FORMAL COMMUNITY SUBMISSION OF OBJECTION

Application Ref: Mixed Use Development (with In-fill Affordable Housing) – 138 Maroubra Road (SSD-81426710)

Impacted Stakeholders: Adjoining Residents and Senior Citizens of the Maroubra Pacific Square Precinct

DRAWN BY	SCALE	SHEET SIZE	PRINT DATE
Author	1 : 500	A1	18/09/2025
DESCRIPTION			5:17:14 PM
SHADOW DIAGRAM PLANS			
SHEET 1			
PROJECT No	DRAWING No	REVISION	
21_435	DA8.300	I

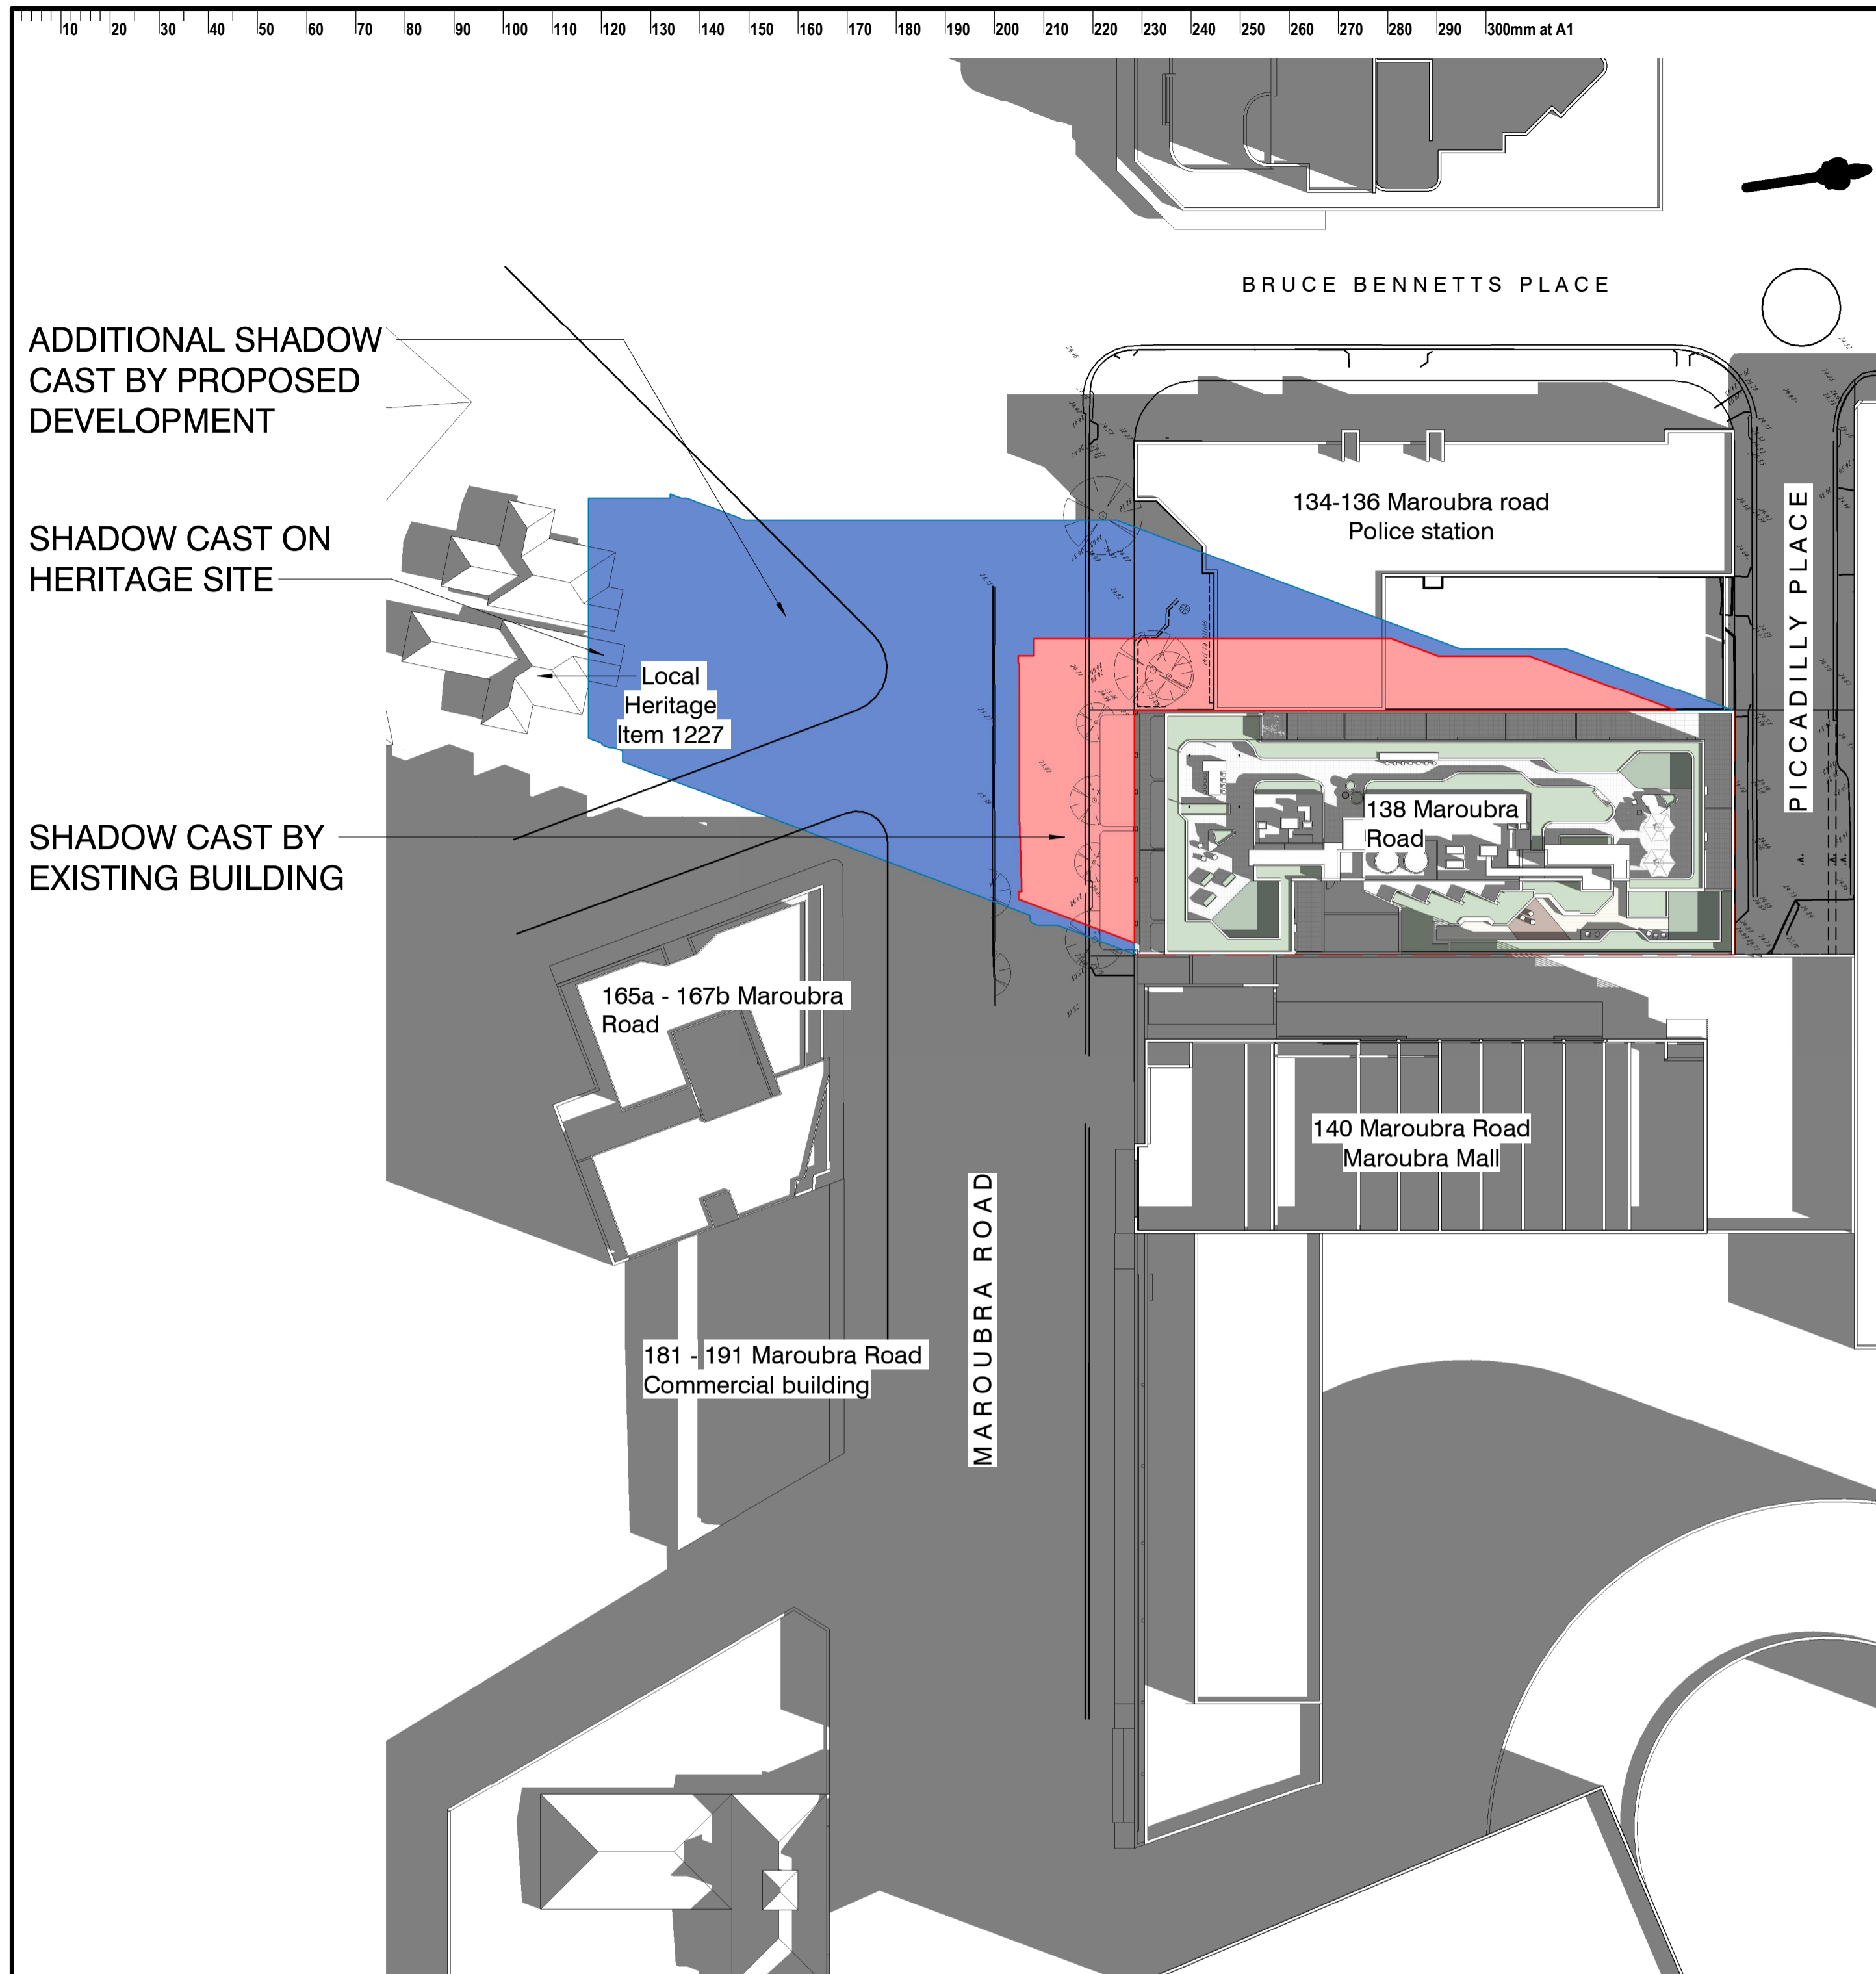
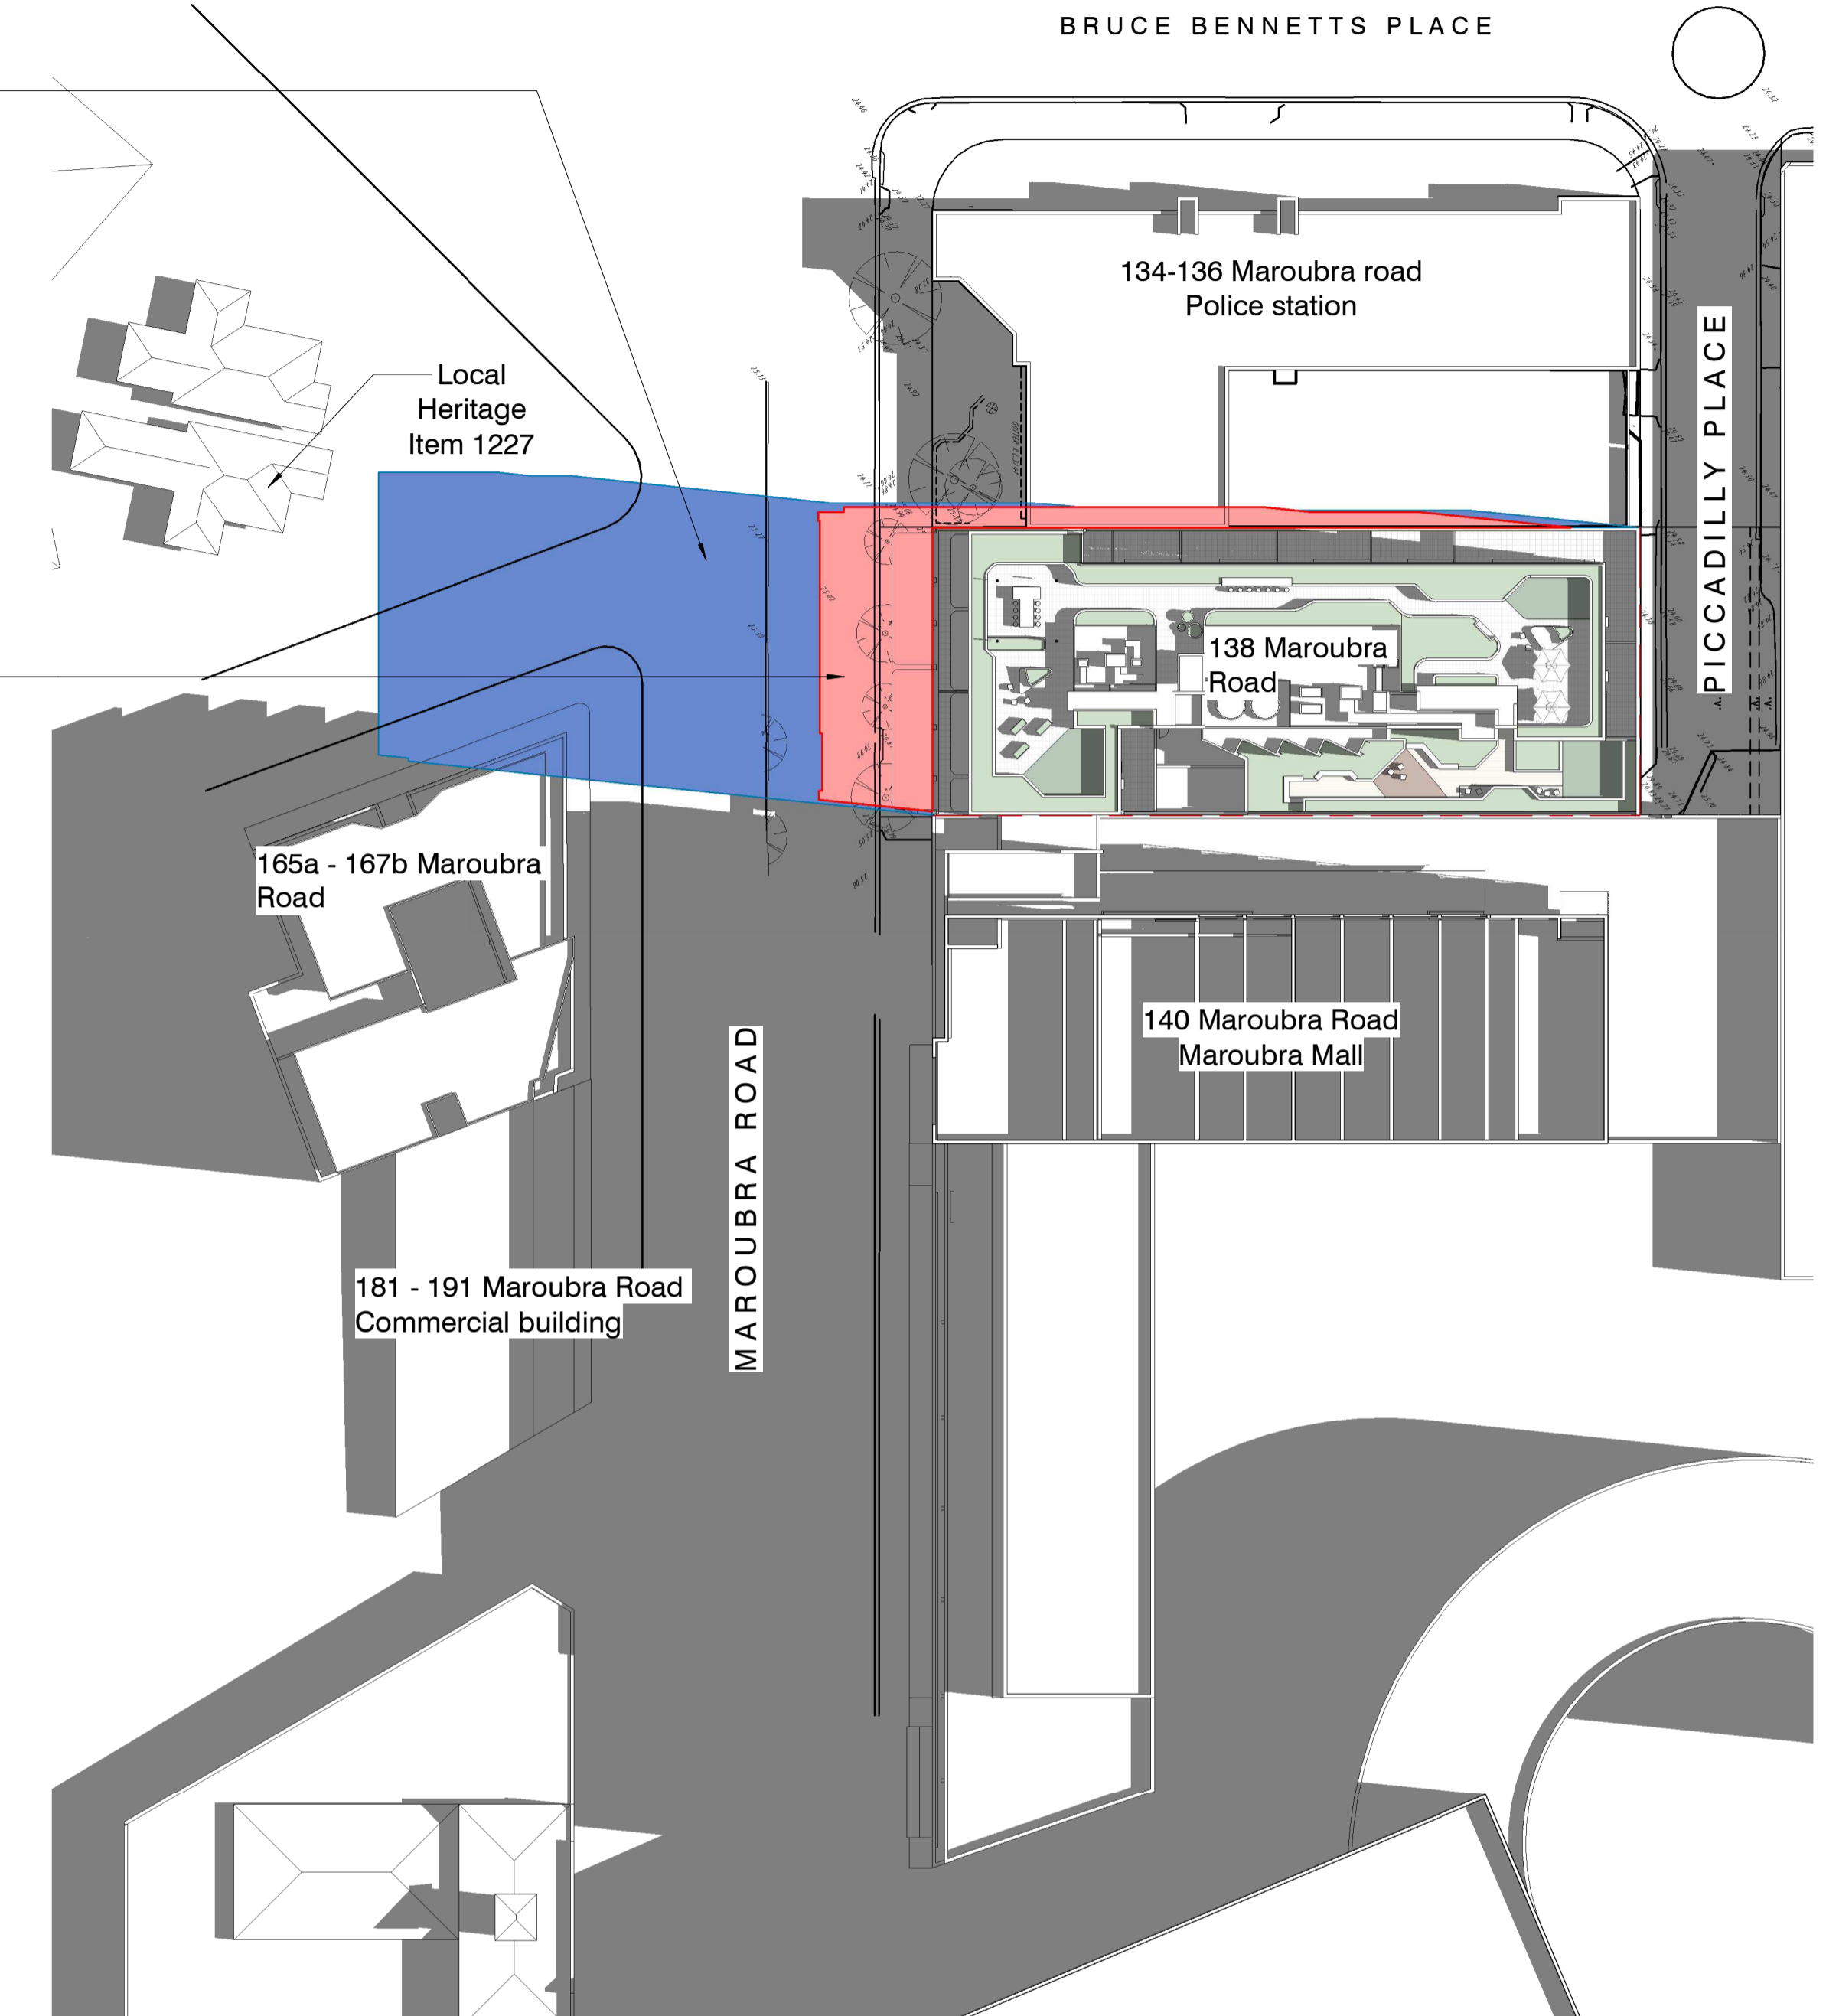
The submitted shadow modeling relies on generic, regional guidelines under the Apartment Design Guide (ADG), completely ignoring the specific microclimatic reality of the surrounding residences. Building a deep, vertical 10-storey structure directly to the west completely cuts off crucial afternoon daylight.

Natural sunlight is an essential requirement for the health, well-being, and internal apartment heating of elderly residents, many of whom suffer from limited mobility and remain indoors. Depriving these living spaces of essential afternoon light hours early creates cold, dark internal environments that directly degrade the daily health and comfort of our senior community.
